Porte Cochere Green Wall

4.7 Signage - Tower

title  
**Signage Elevations**  
**Signage Detail Elevation - Tower West**

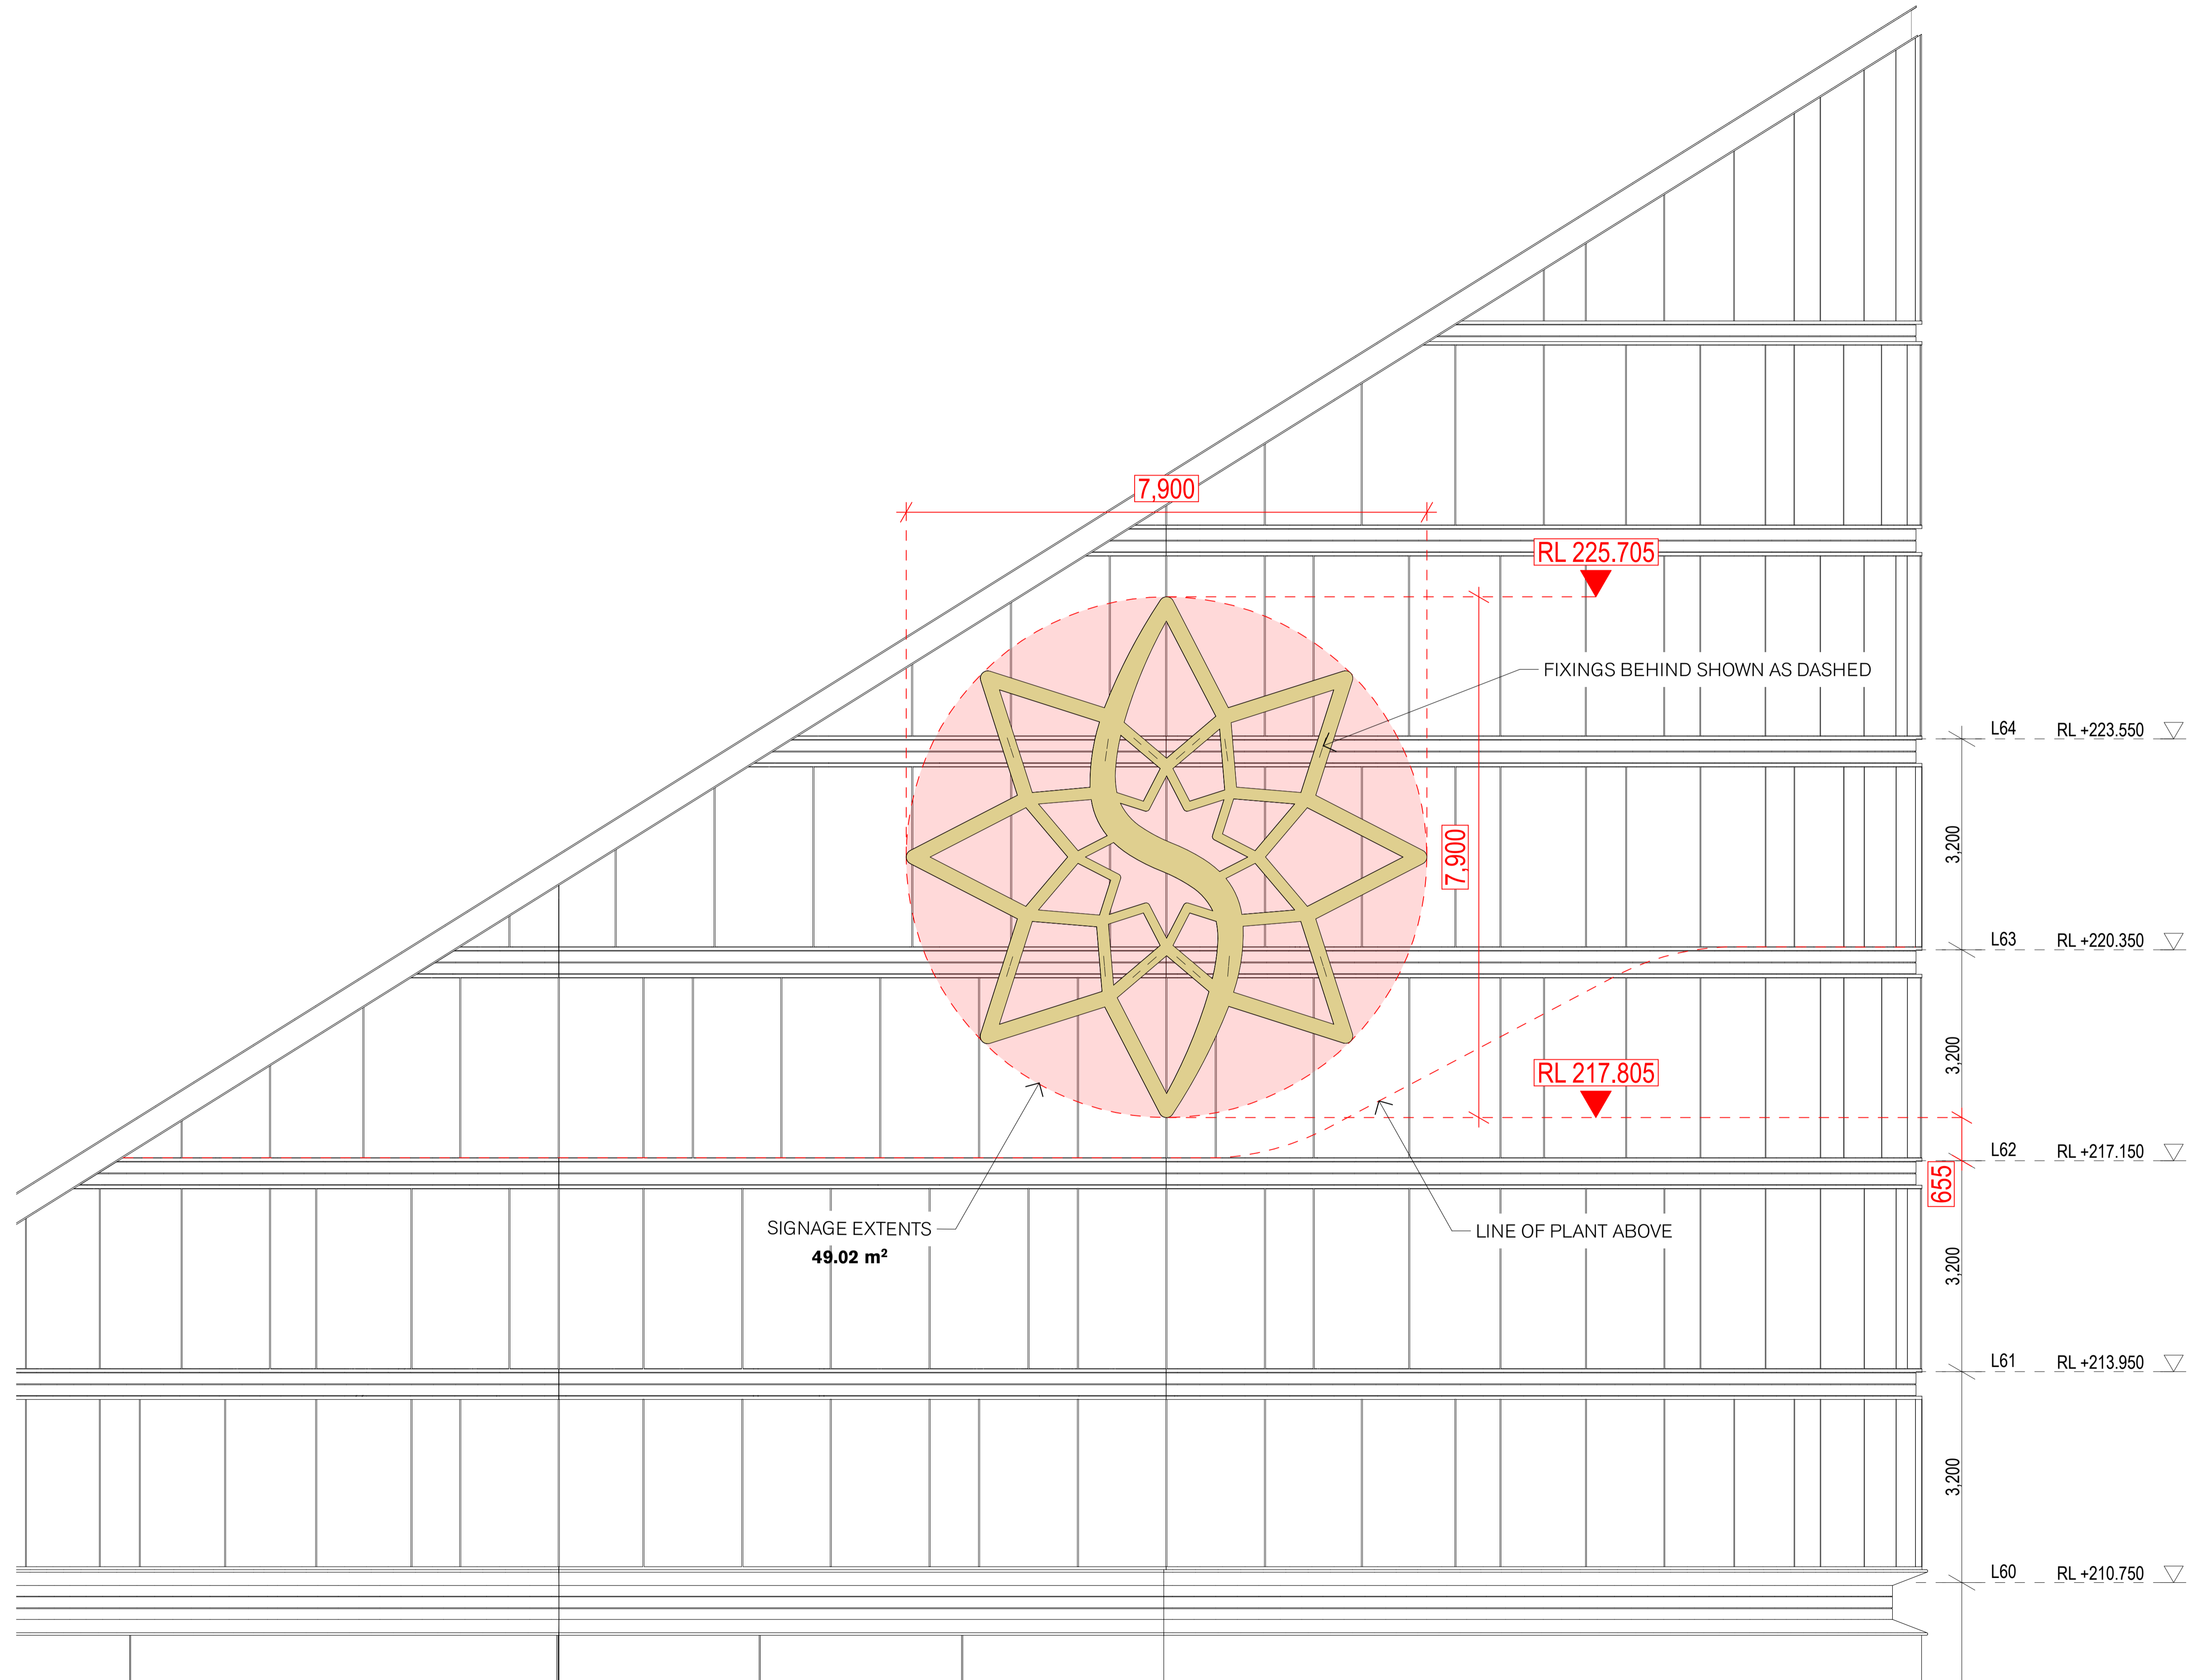
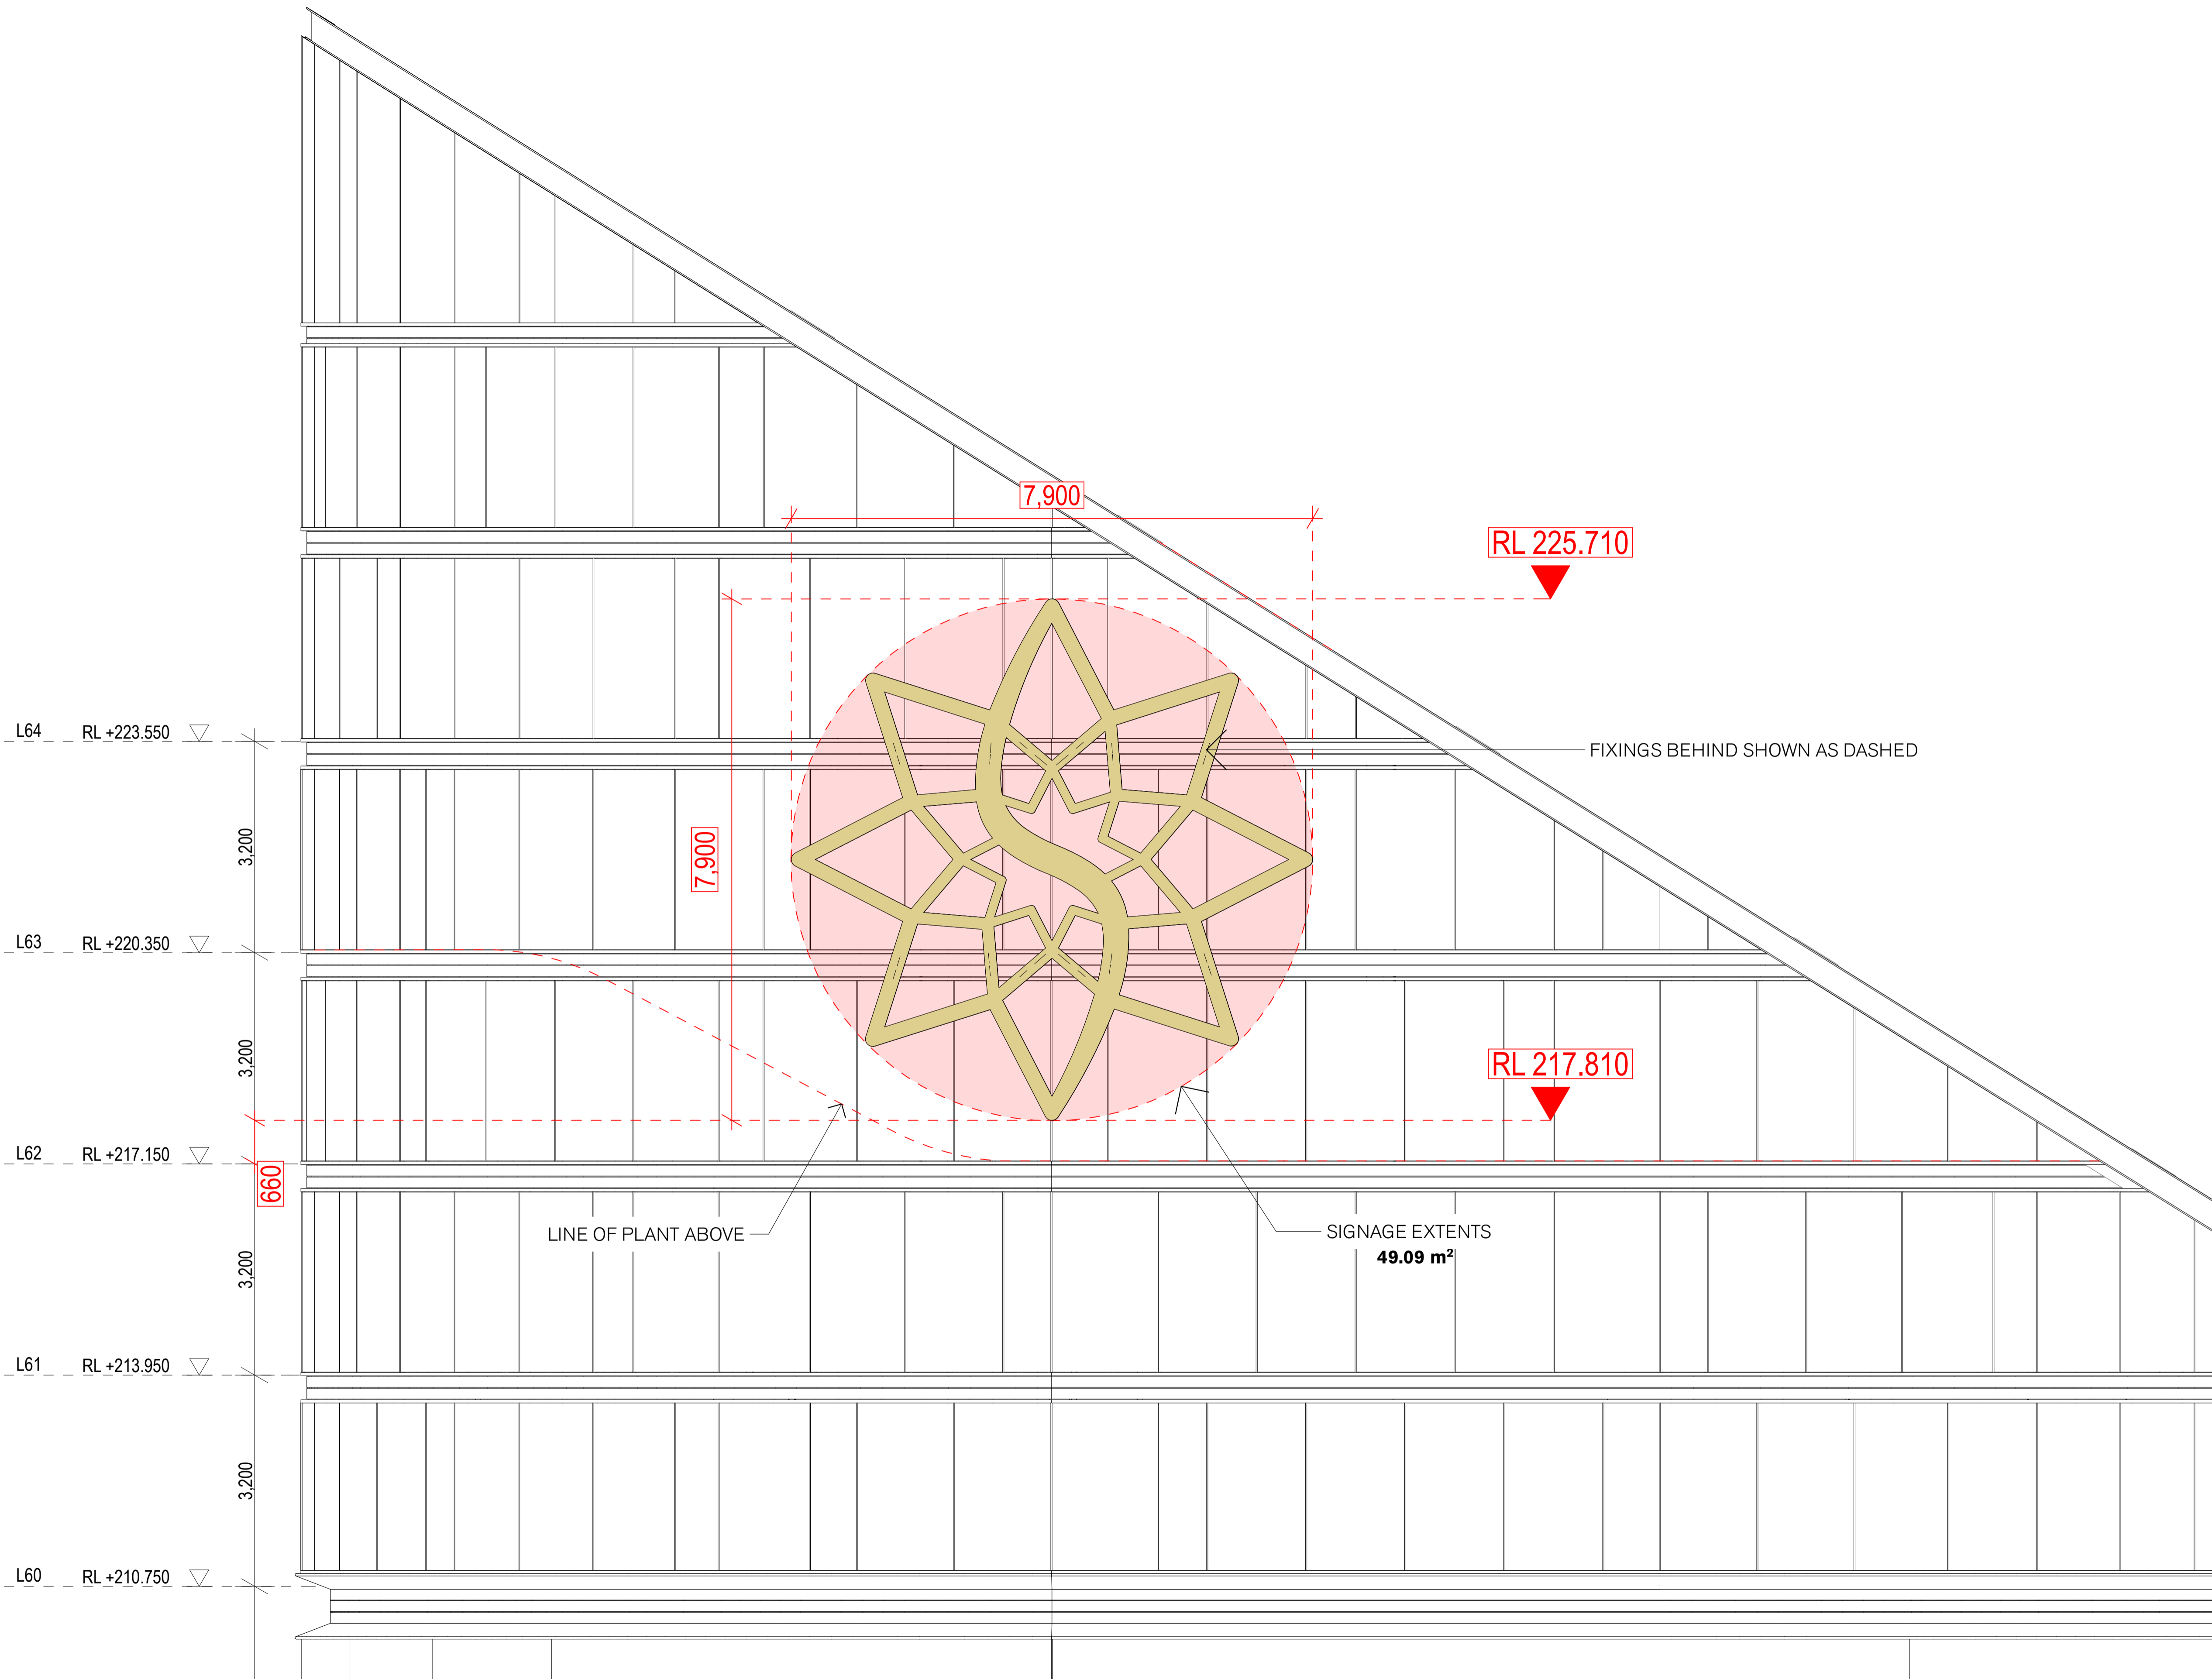
Department of Planning item:  
"Consider reducing the size of the roof-level signage on the tower having regard to the proportions of the roof and other comparable roof-top signage approvals within Darling Harbour"

The proposed sky signage has been reduced from 8.2m diameter to 7.9m diameter to ensure it is appropriately sized with consideration of other sky signage within Darling Harbour.

The dimensions of the Tower signage has been reduced since formal lodgement from 8.2m to 7.9m diameter, giving an area of **49m2**. At RL +237.000m (AHD) this provides ration of tower height to signage height of **30:1**.
